December 15, 2022

John & Drennan Fuller

Re: Limited Structural Inspection  
93 Marian Lane  
Spring Lake, NC

CRAWL SPACE REPAIR SKETCH

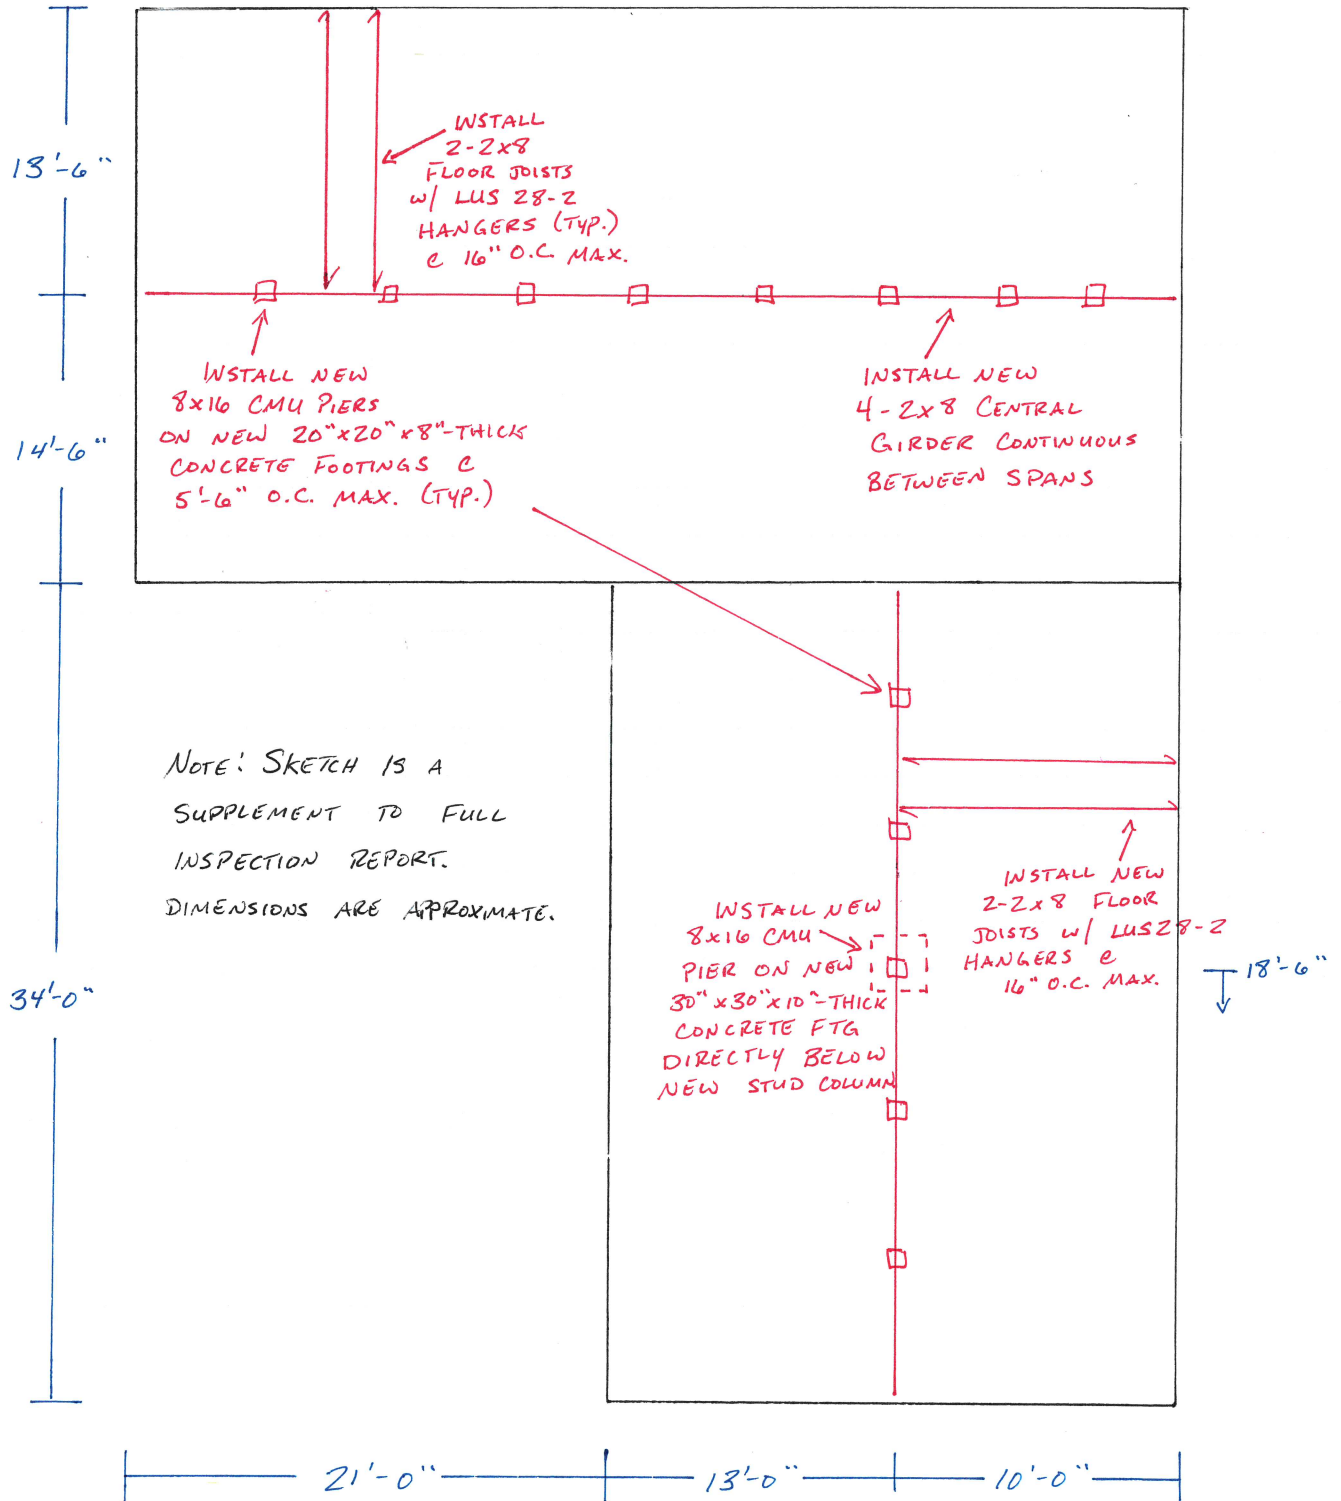
- b. The central spans of the rear girder, beginning approximately 17’-0” from the left perimeter wall and extending to the right approximately 23’-0” were noted to be significantly deteriorated due to previous moisture/wood-destroying insect activity. The girder exhibited cross-sectional losses of up to 2”. Additionally, a section of the central girder was noted to be missing and improperly supported at the right side of the crawl space beginning approximately 2’-0” from the right foundation wall.

- c. Multiple CMU piers were noted to be improperly installed and were noted to be cracked at the center of the crawl space. The presence of concrete footings beneath the CMU piers could not be determined at the time of the inspection.

3. We recommend replacing the existing central girders in both crawl spaces to properly support the floor framing. Each new girder shall consist of a 4-2x8 member and shall span continuously between supports and be supported by new 8x16 CMU piers spaced at a maximum of 5'-6" apart. The new CMU piers shall bear directly on new 20"x20"x8"-thick concrete footings (unless otherwise noted). Provide 2x pressure-treated blocking between the floor girder and new piers. (See attached sketch)

FLOOR JOISTS

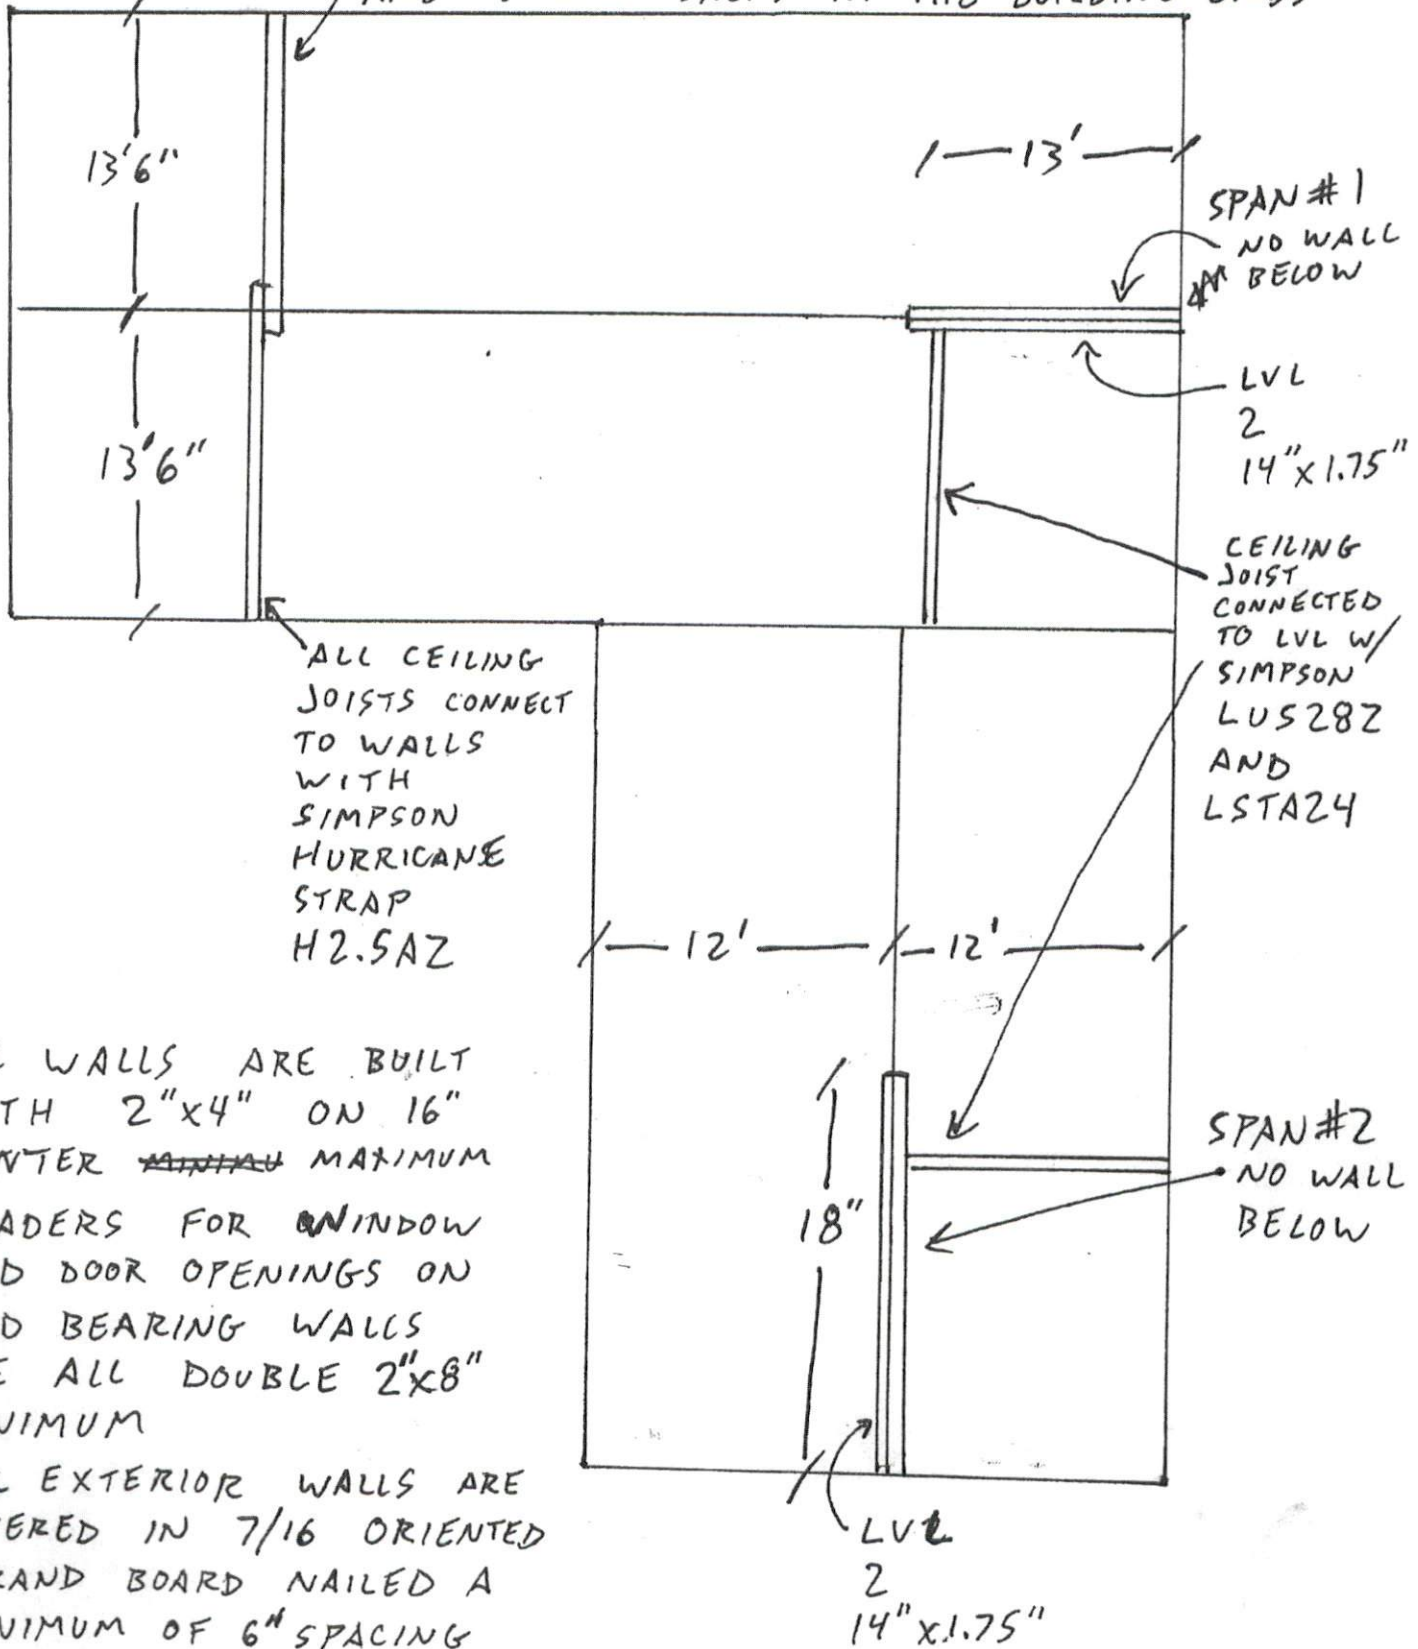
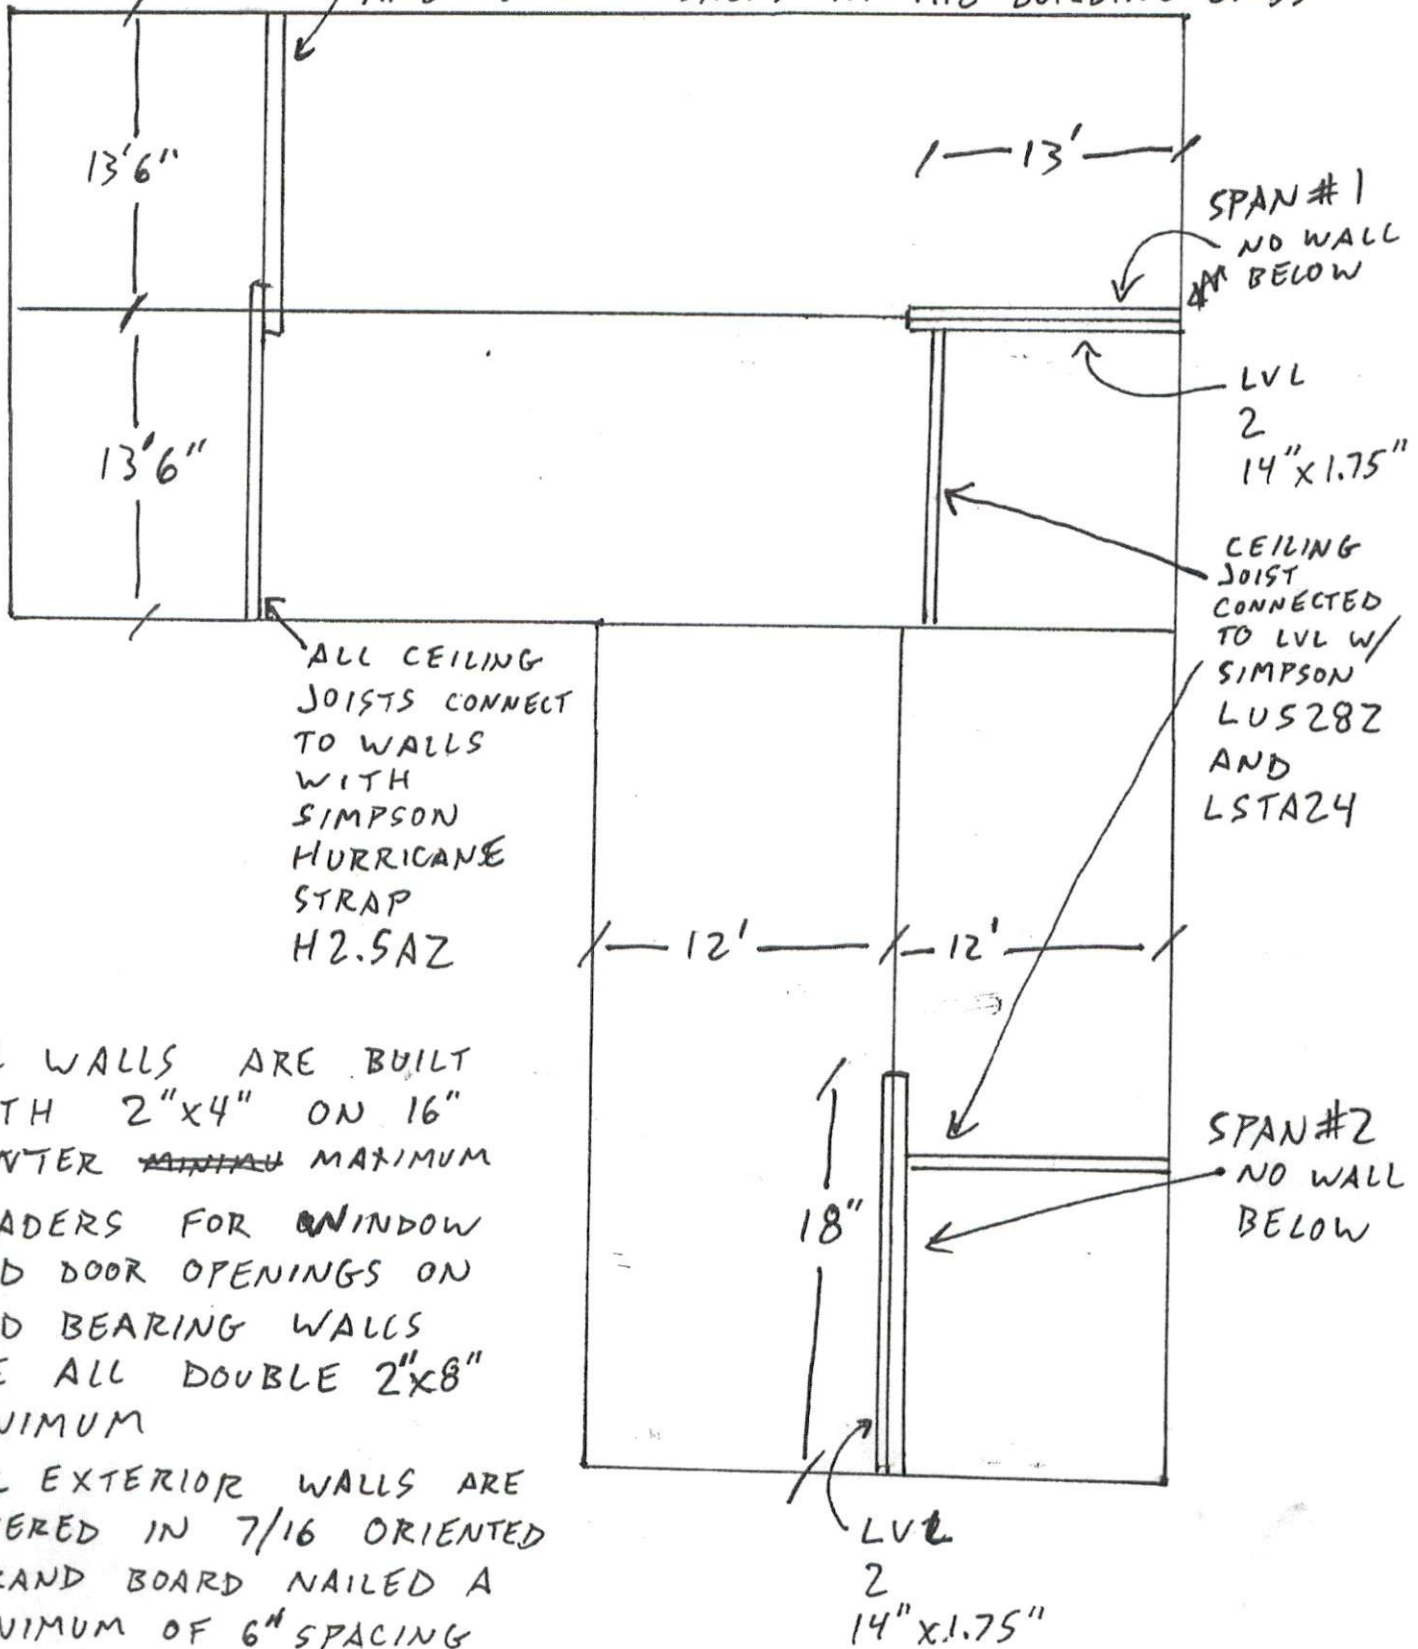
- a. At the rear of the home, multiple floor joists were noted to exhibit significant wood-destroying insect deterioration. The joists were probed with an awl and exhibited up to 3” of cross-sectional losses at the time of the inspection.

- d. At the front of the crawl space, multiple floor joists were noted to exhibit significant wood-destroying insect damage. The joists were probed with an awl and exhibited up to 2” of cross-sectional losses.

4. We recommend replacing all damaged floor joists with new 2-2x8 floor joists attached at both ends with new Simpson LUS28-2 joist hangers. The floor joists should be spaced at a maximum of 16" on-center. We recommend fully sistering the remaining floor joists with a new 2x8 member attached with (3) 10d nails at 16" on-center. The newly sistered joists should be attached at both ends with Simpson LUS28-2 hangers.
